Please ask for: Mrs D Johnson
Email: daun.johnson@arun.gov.uk
Telephone: 01903 737762
Our Ref: WA/93/21/PL
Your Ref:
Date: 30th September 2021

Application for Planning Permission

Development: New detached dwelling & detached garage. This site is in CIL Zone 3 & is CIL Liable as new dwelling.
Location: Land Adjacent To Oak Bank Wandleys Lane Walberton BN18 0QR

Site Block Plan 1:200

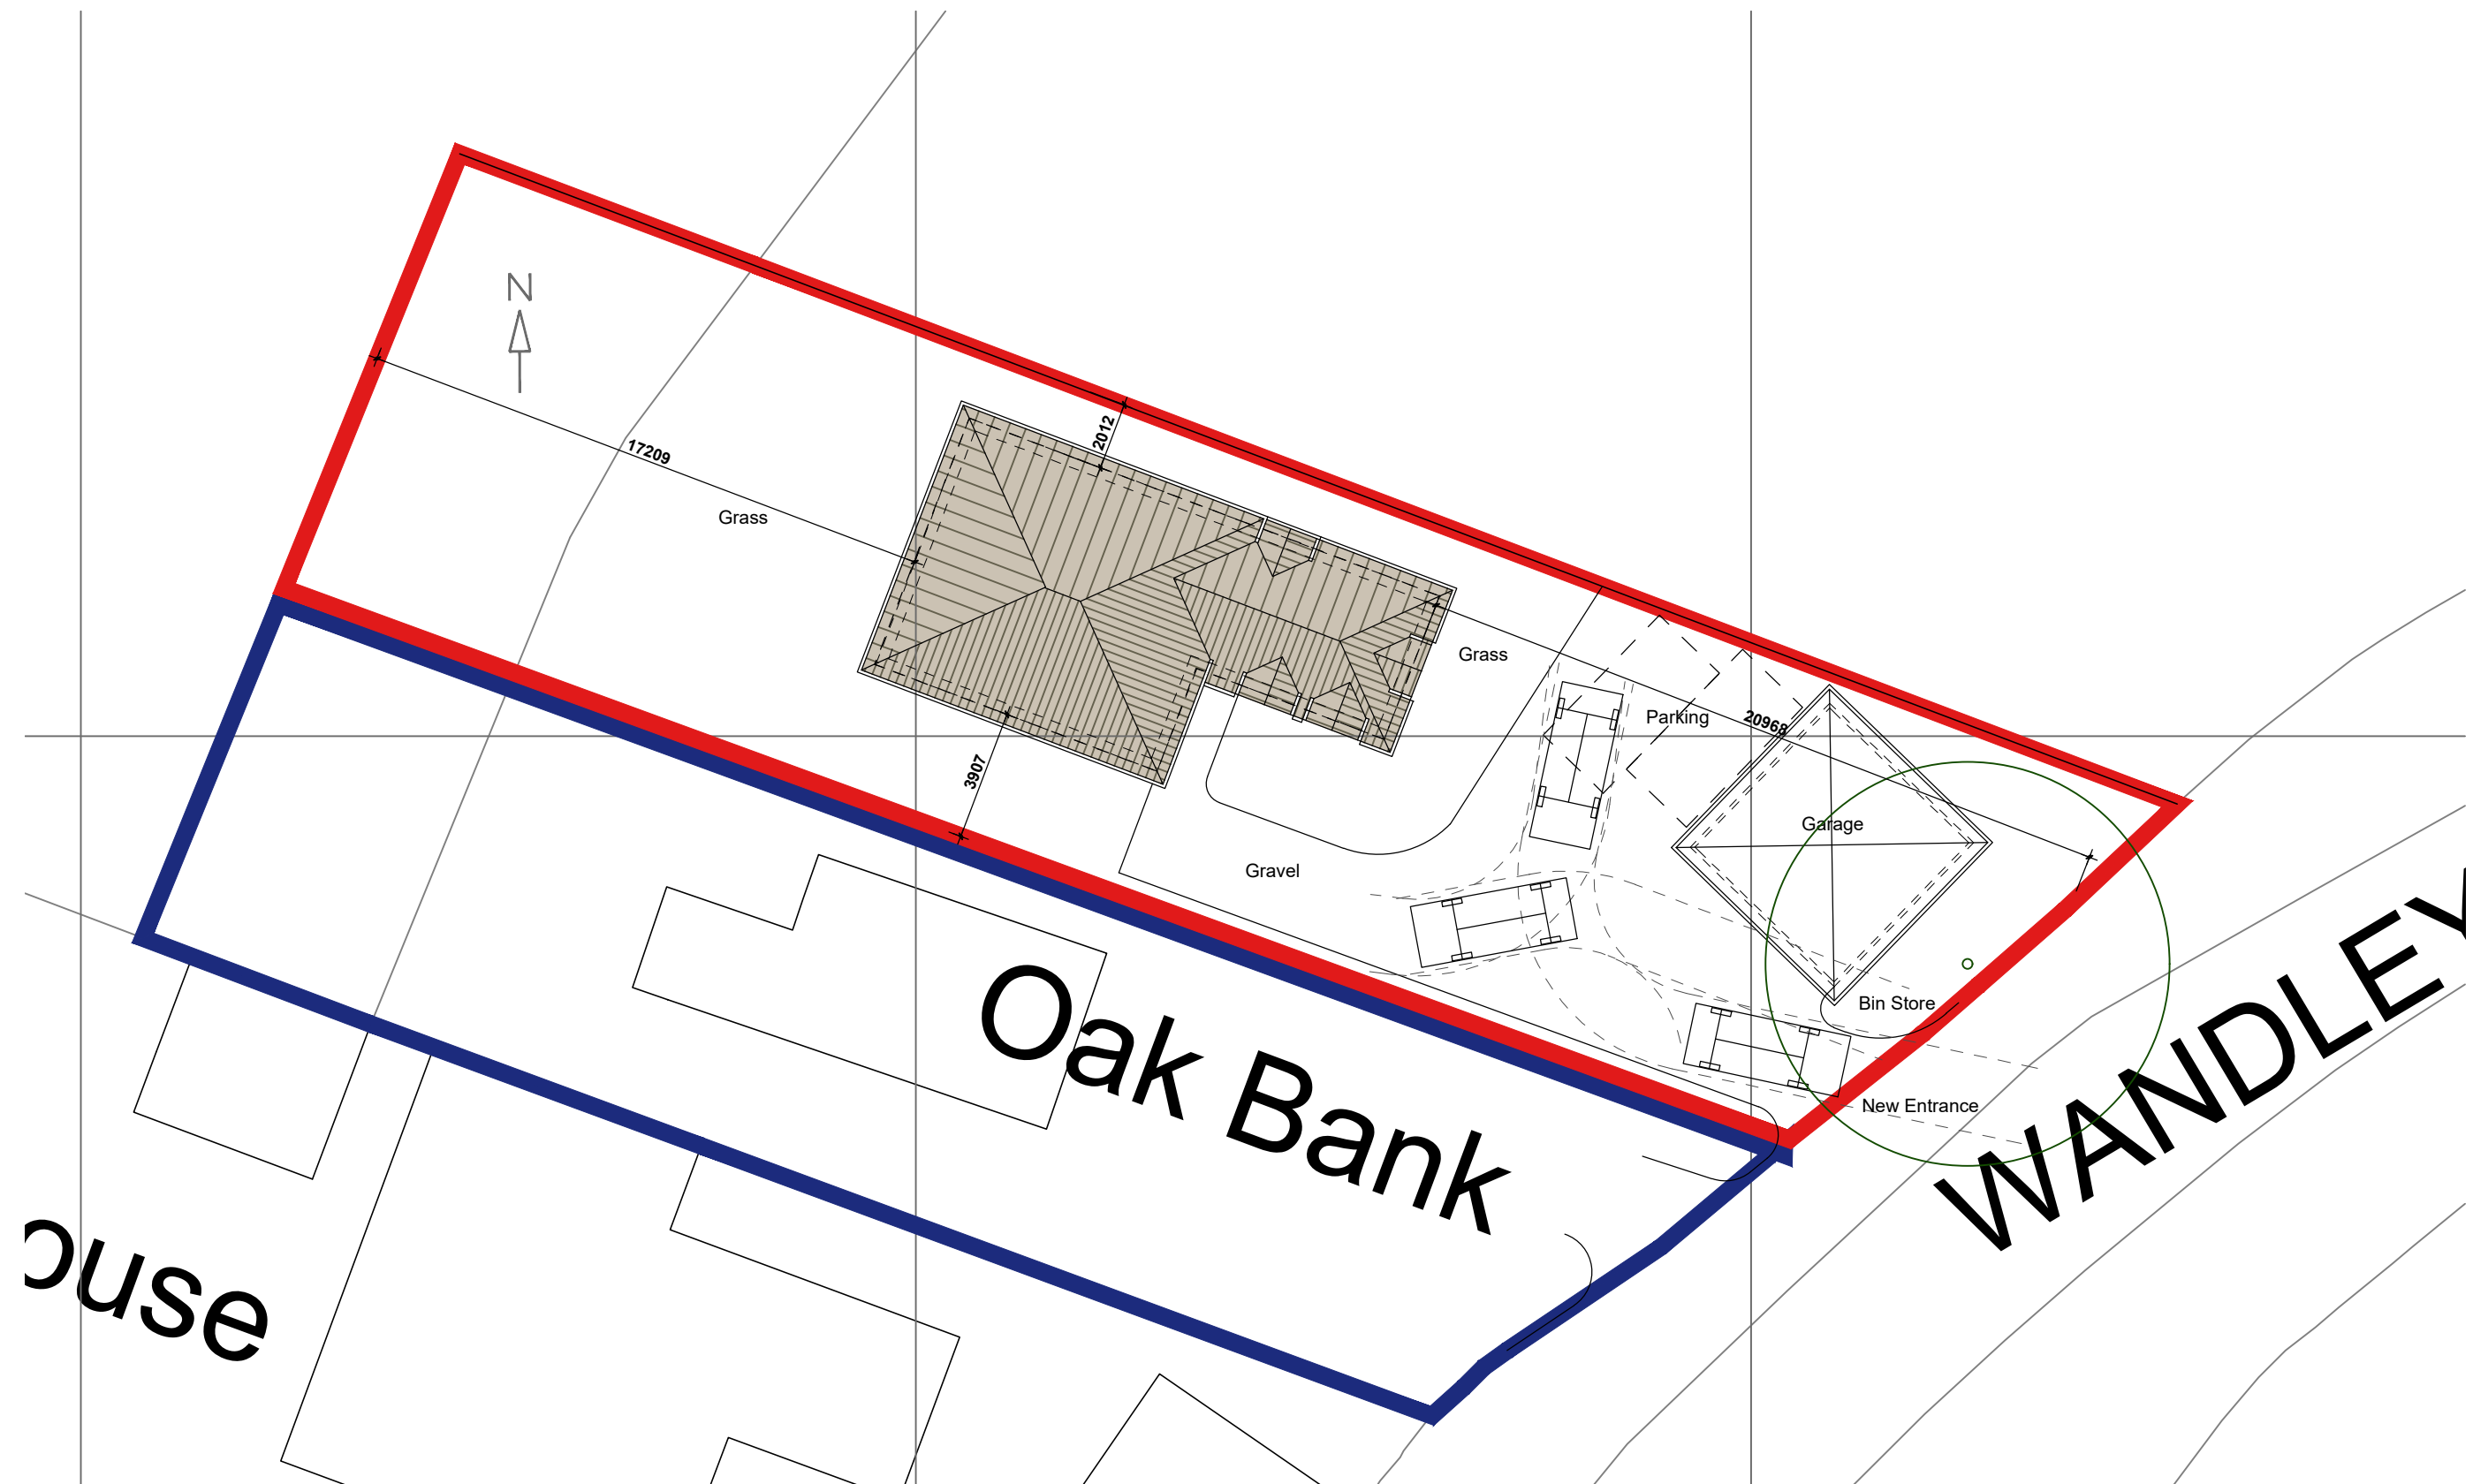
Block Plan

Please provide measurements from the proposals to the site boundaries.
CIL Additional Information Form

Garage Plan

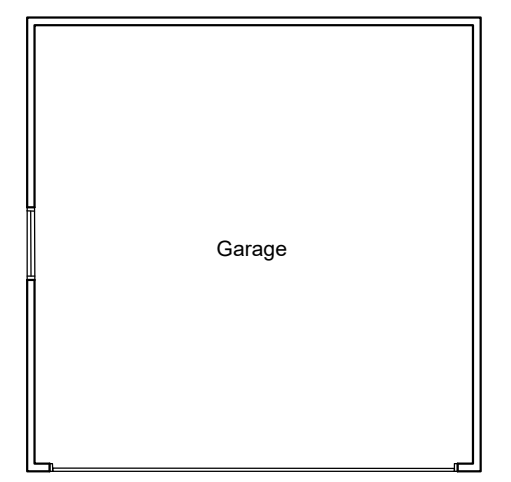
Please provide floor plans for the proposed detached garage.
